Interested Party Reference: ██████████ **5 Project:** One Earth Solar Farm (EN010159)
Submission Type: Written Representation in Response to the Secretary of State's Consultation Letter dated 21 May 2026 (Requesting Responses to the Post-Examination Submissions Regarding Draft Requirements 7 and 22)

SUBJECT: Fatal Invalidation of the Baseline Safety Case, the Extent of Required Redesign, and the Breach of EIA Precedence Following the Environment Agency (EA) May 28, 2026, Flood Map Updates.

Drawing Title:
Surface Water Drainage Strategy
Western BESS Compound

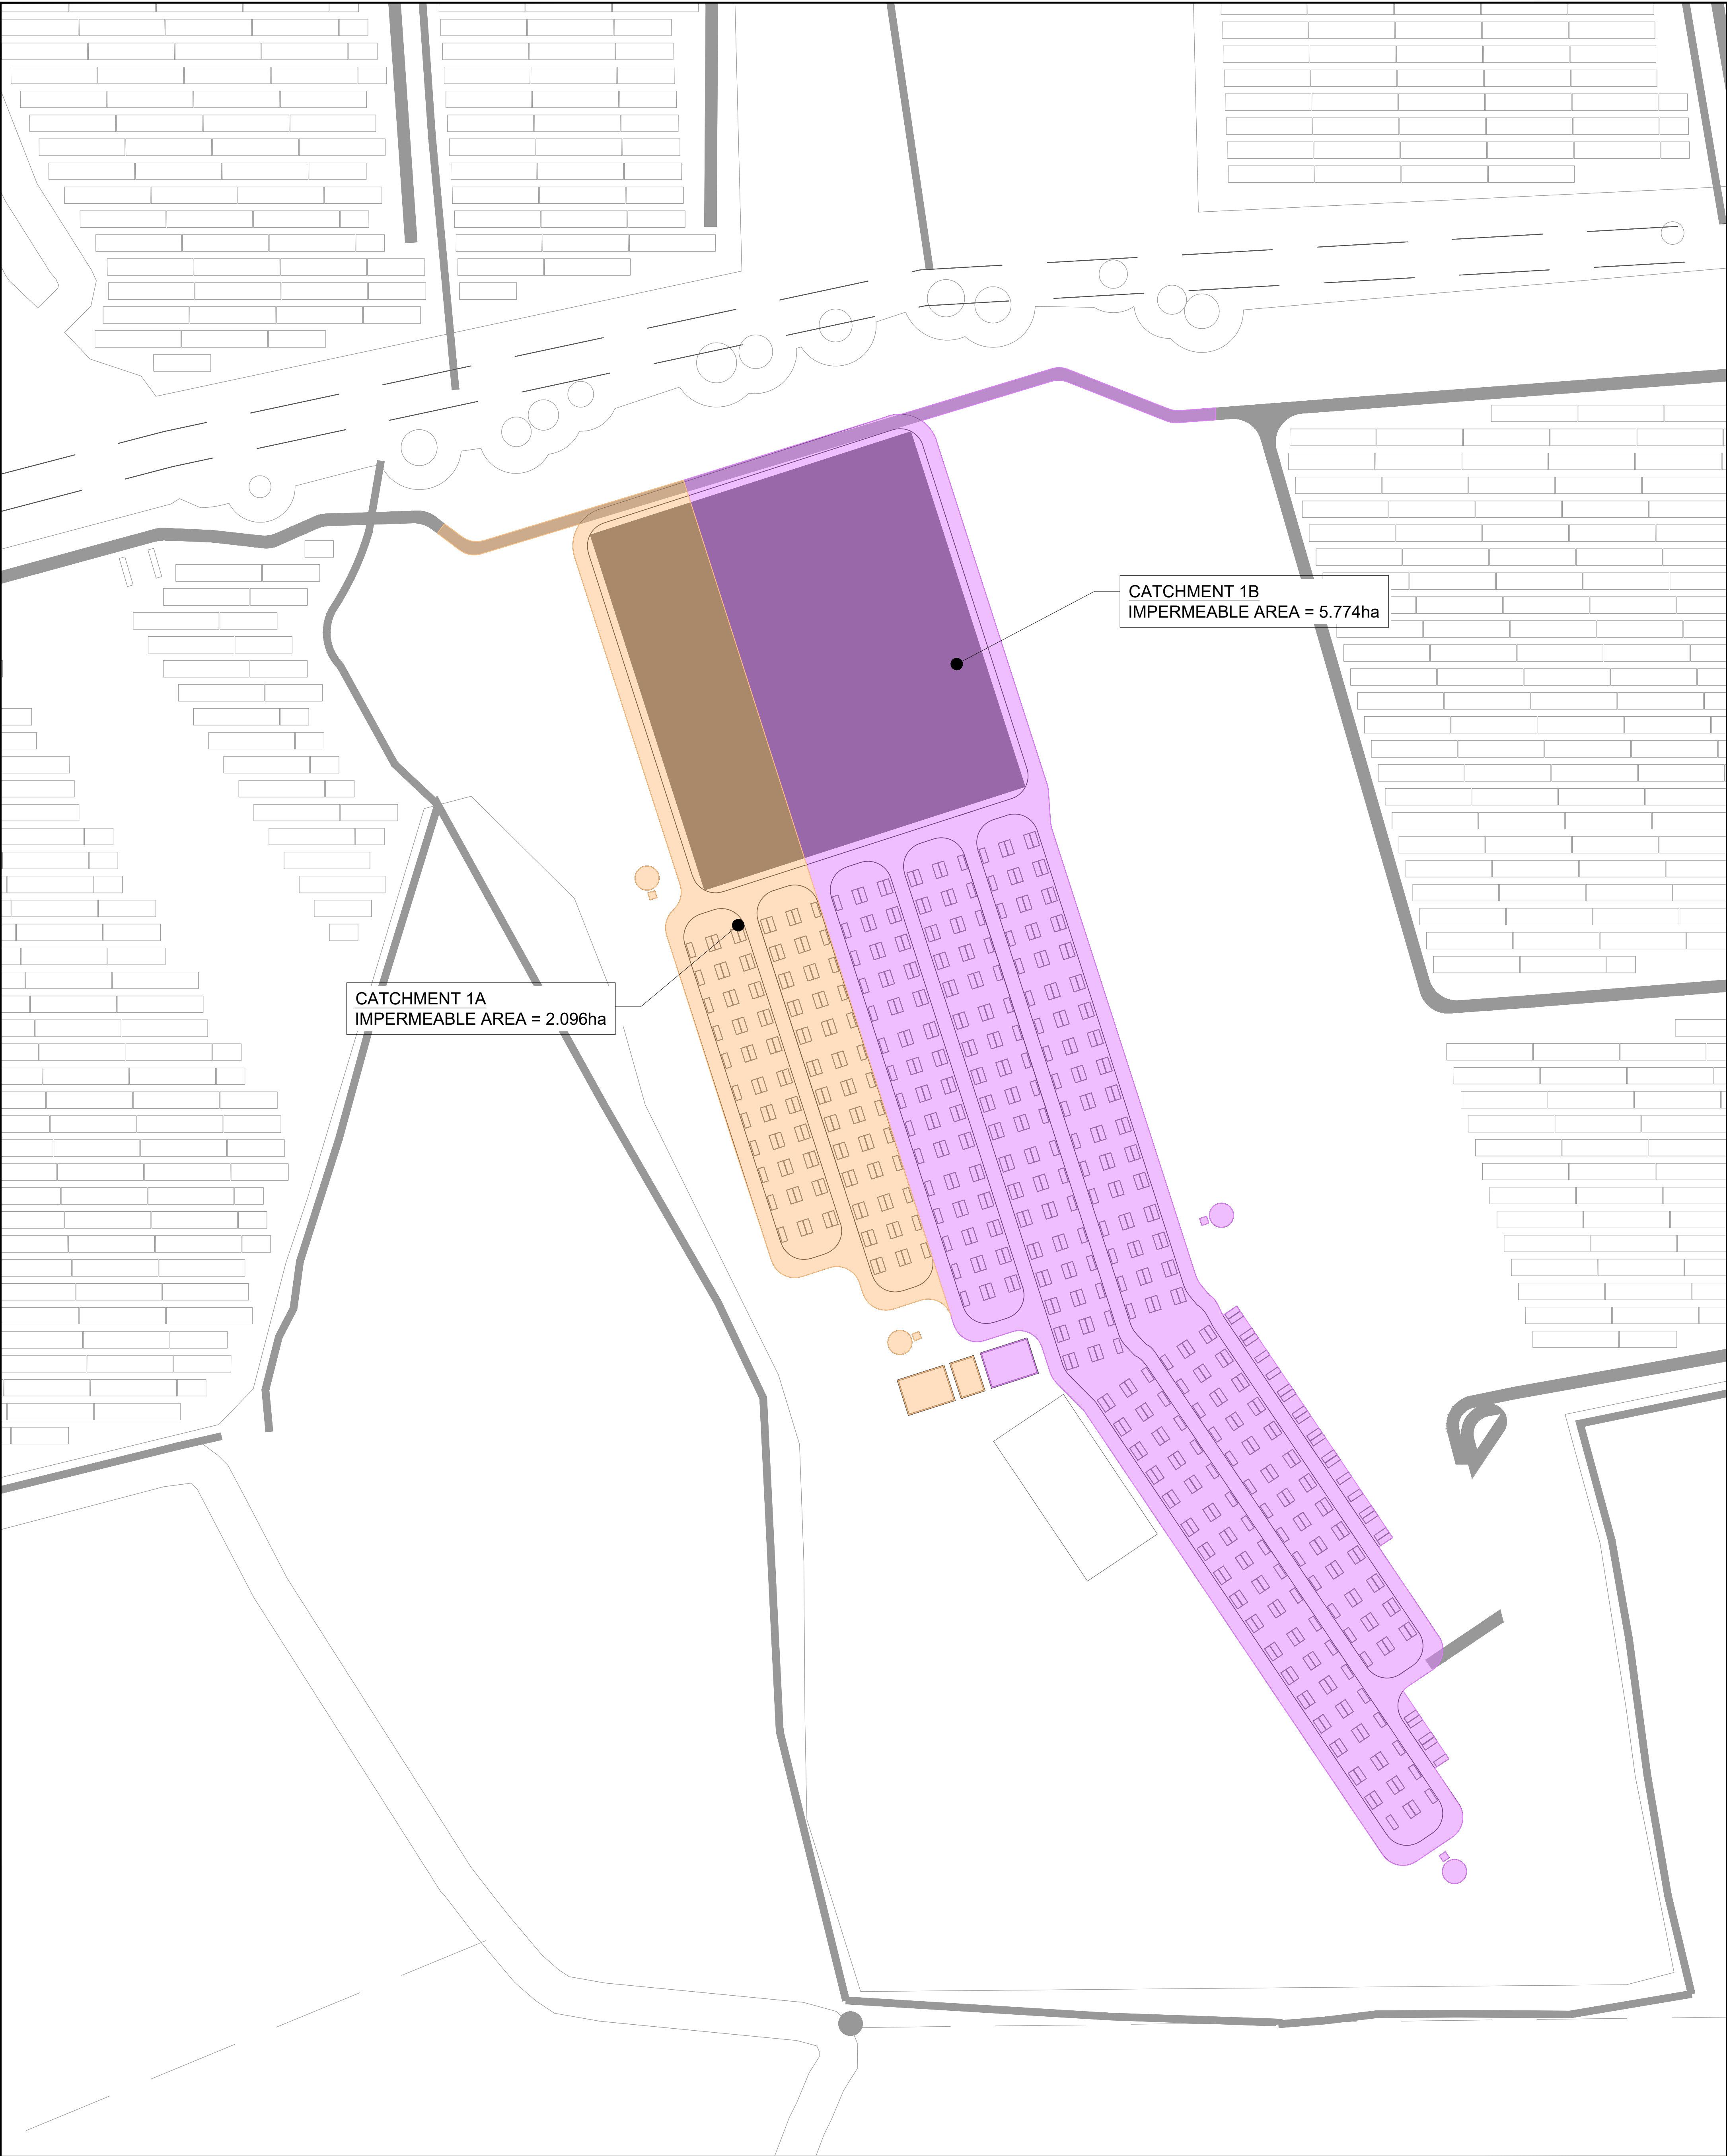
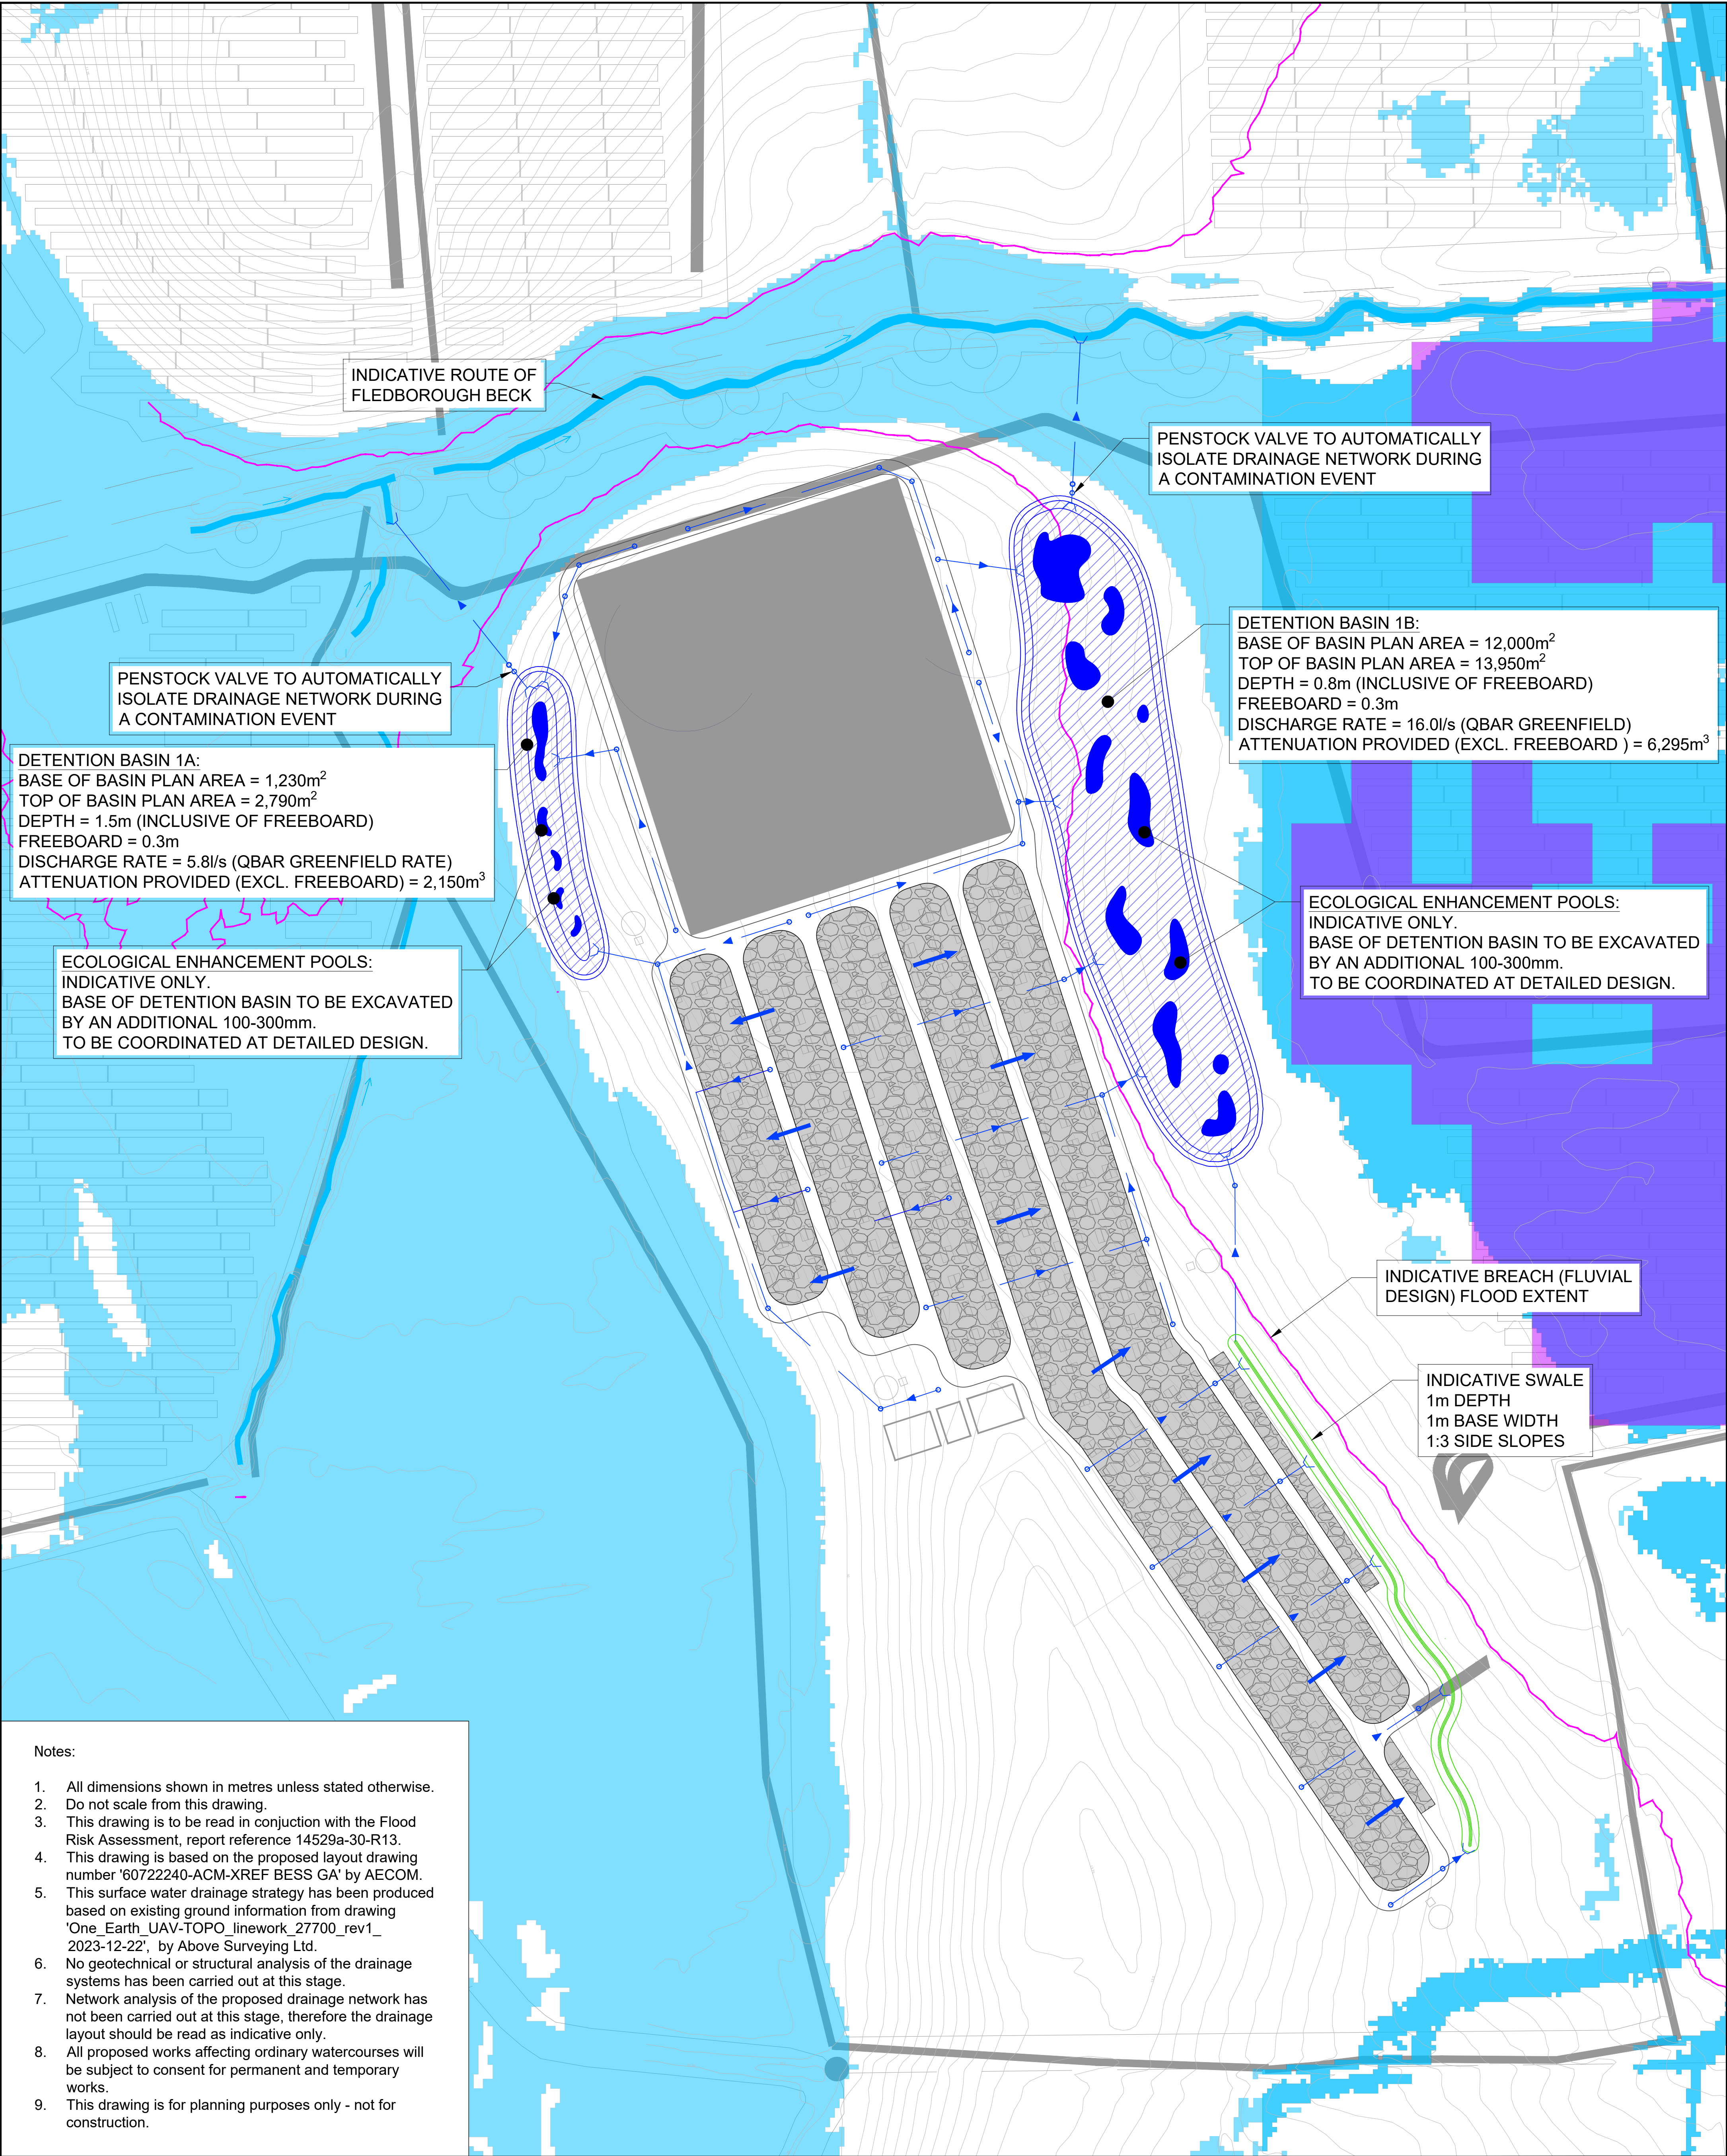
The May 28, 2026, FMfP update completely invalidates this spatial safety assumption. The updated models confirm that active surface water runoff channels, carrying a 300mm to 600mm banded depth in a 1% AEP event with climate change, cut directly through the planned footprints of these combined 197,000 m² compounds, as well as their sole operational access tracks¹⁹.

This active pluvial inundation represents a fatal statutory safety failure under the DCO. The Secretary of State's legally binding Requirement 7(2) mandates that the battery safety management plan must demonstrate that all required emergency and operational access to the BESS and substation compounds is "achievable and safe during the design flood event"²⁰. Because deep, active pluvial flow paths now directly intersect these access routes and compound footprints at their current designed grade, safe transit is physically impossible during the design event, and the scheme fails this core safety mandate²¹.

To protect the critical electrical infrastructure and satisfy the Secretary of State's Requirements, the applicant would be forced to execute a massive structural and spatial redesign. Specifically, the entire 197,000 m² footprint of the BESS and Substations, along with their access roads, would need to be artificially raised on solid earth platforms or concrete plinths by at least 1.5 metres to evade the mapped floodwaters. This proposed redesign triggers insurmountable legal, policy, and procedural barriers under UK planning law.

Siting a 1.5-metre raised solid platform across a massive 197,000 m² footprint acts as an impermeable dam. This directly violates Paragraph 5.8.12 of the Overarching National Policy Statement for Energy (NPS EN-1), which dictates that there must be "no net loss of floodplain storage" and that any deflection or constriction of flood flow routes must be safely managed within the site³⁴. Blocking newly mapped active pluvial flow paths with 197,000 m² of raised infrastructure would dangerously constrict surface
